Application: SSI 7485

I write regarding the proposed modification to M4-M5 Link, Mod 2 The Crescent overpass and changes to pedestrian infrastructure in North Annandale, Rozelle and Rozelle Bay Foreshore area.

Figure 4-2 Pedestrian and cyclist bridge infrastructure options

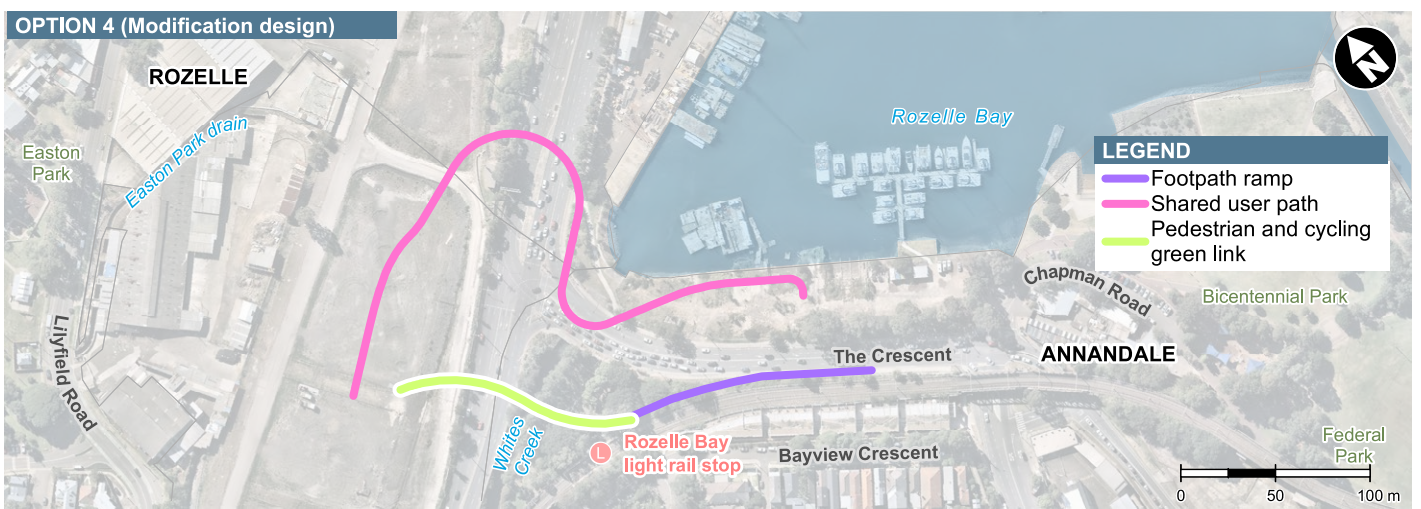
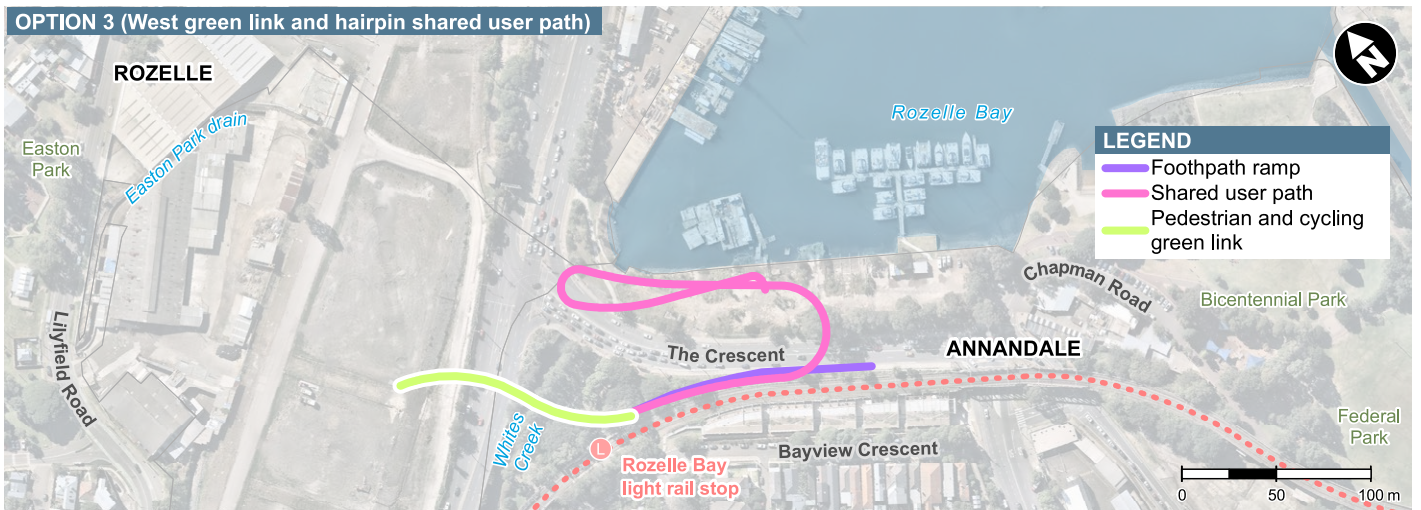
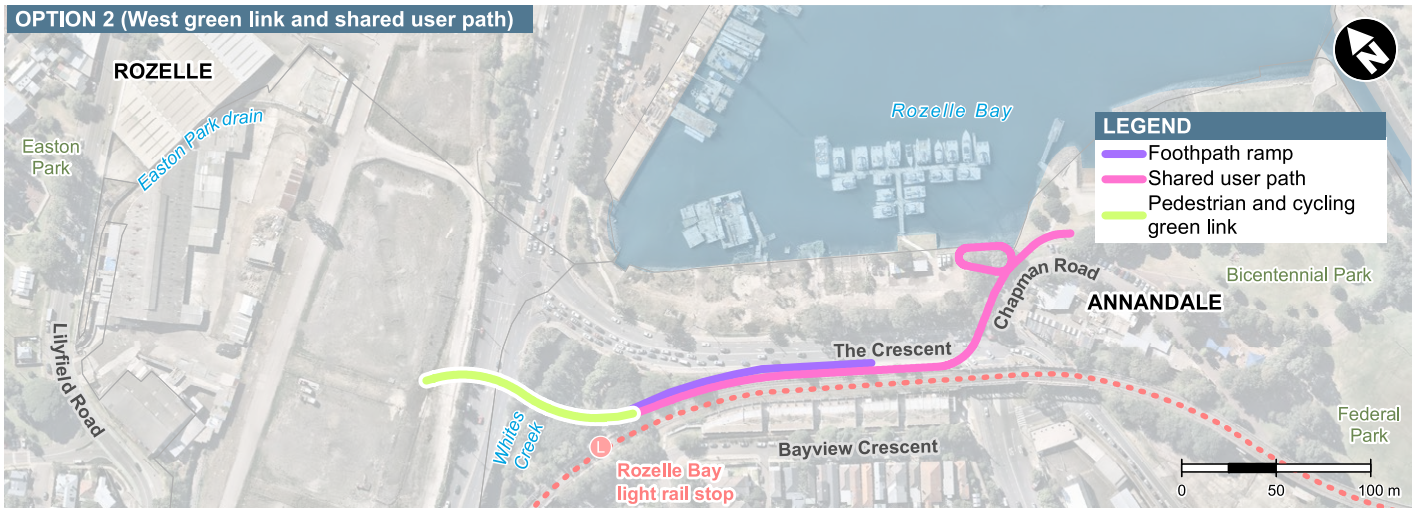
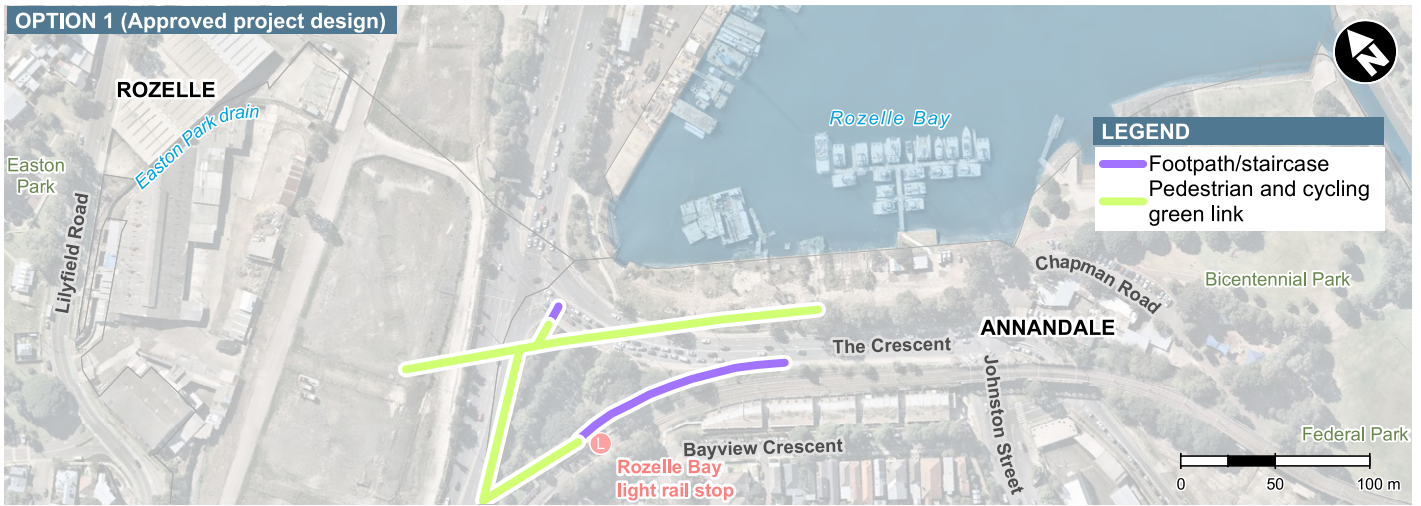
I request RMS work with the community to explore alternate design options to the proposed new car overpass design and the changed pedestrian and cyclist links. I am seeking the reinstatement of the safe, direct access from the approved EIS GreenLink to create a continuous green open space connection from the Rozelle Rail yards and Annandale to the foreshore. The GreenLink was more than just a walk way - it put people central to the design, maximising safety, and providing much needed accessible open space for the community now and into the future Bays Precinct design.

- Reinstate the GreenLink connecting communities and green open space from Rozelle to Bicentennial Park
- Relocate and design pedestrian and cyclist connections that are continuous, safe and direct.
- Design the modification infrastructure and active links in response to the character of the suburbs, the location of the foreshore and it's potential future development.
- Provide pedestrian and cyclist paths that maximise people safety and do not force them onto busier streets, unsafe concrete plazas and caged walkways.
- Integrate active and direct connections to all active transport – including the future Metro West and Foreshore Ferry Wharf

Figure 4-4 Elevation: Indicative view of The Crescent overpass

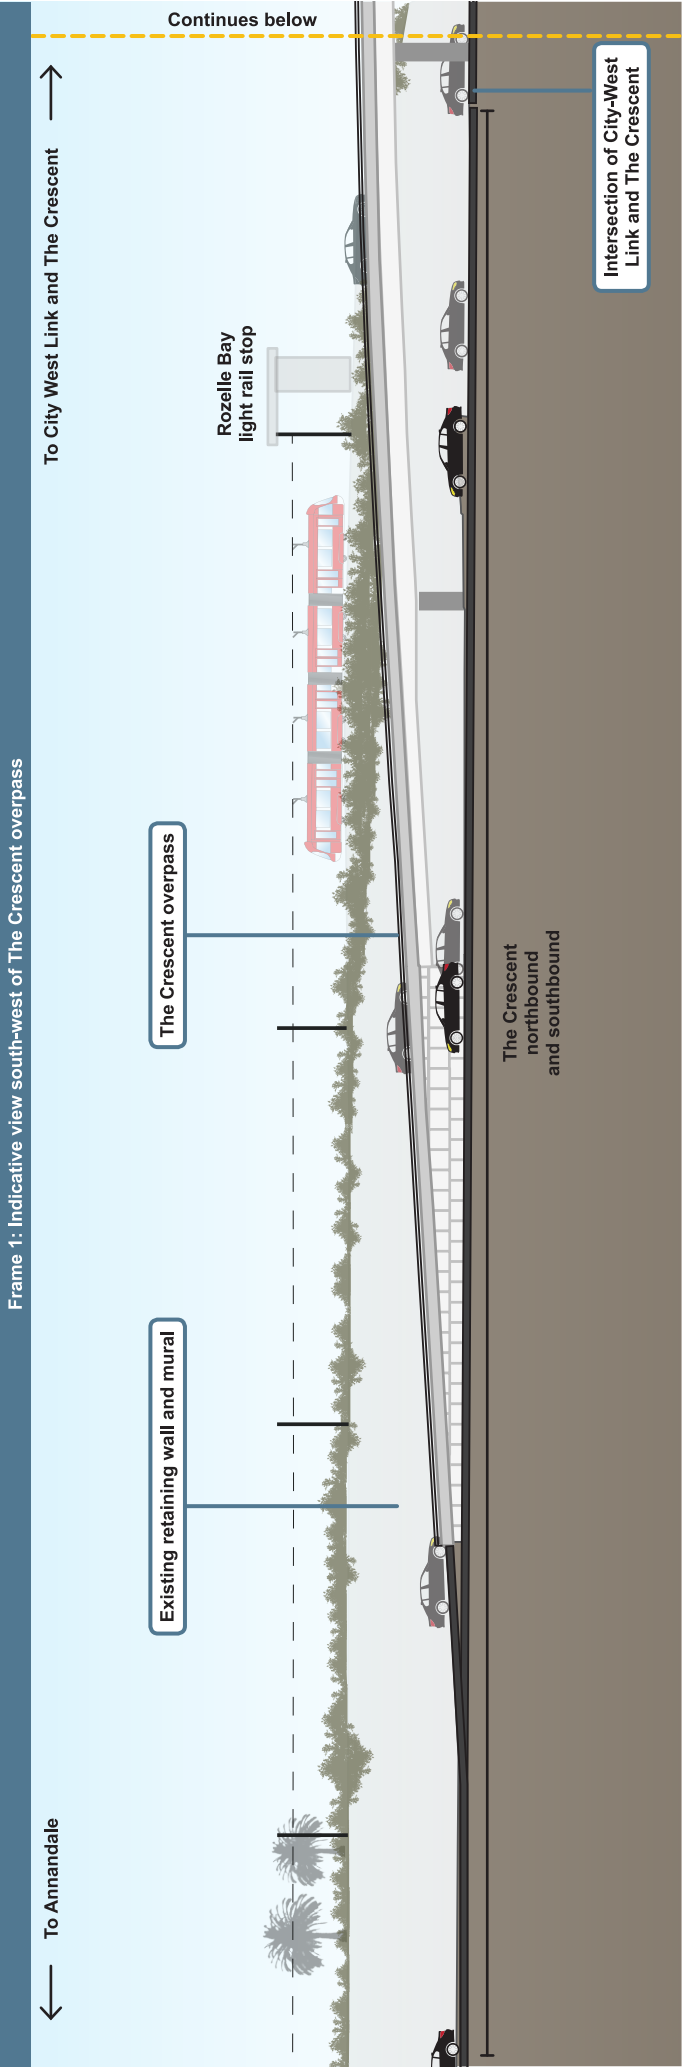
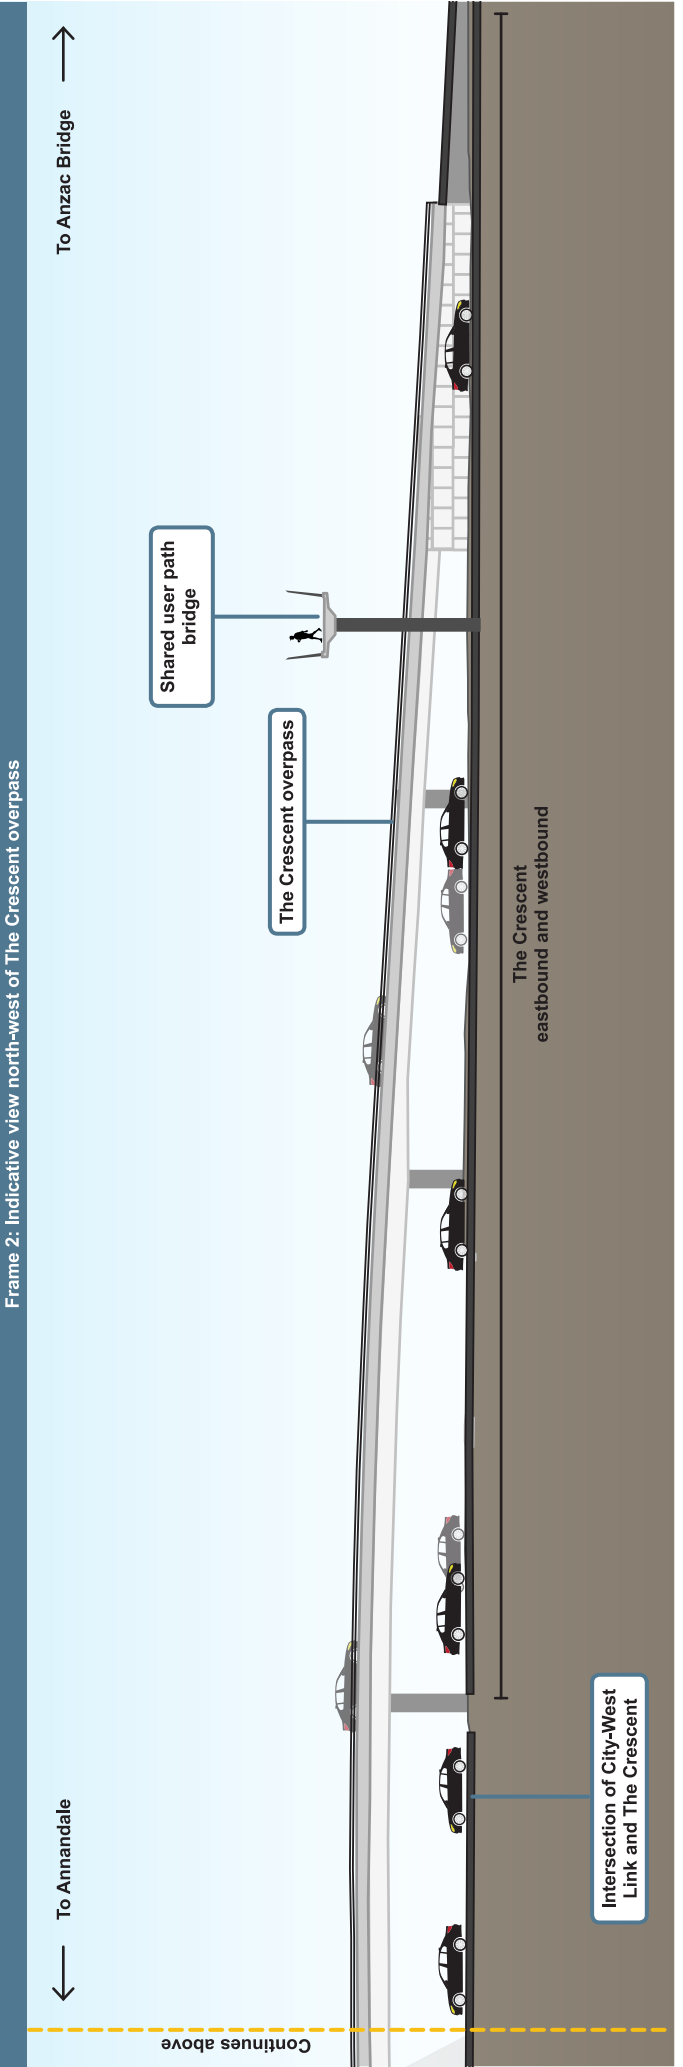
Sydney attract many tourists due to the beauty of the city especially the foreshores. Do we want yet another Cahill expressway? Absolutely not. This proposal for such a monstrosity build to save money is so short sighted that even a child could find a better solution.

*Go back to the first thinking! put it underground.
It is more expensive but that save us spending
much money in 20 years time when some
people with more sense, to pull an ugly overpass
down and then put it underground.*
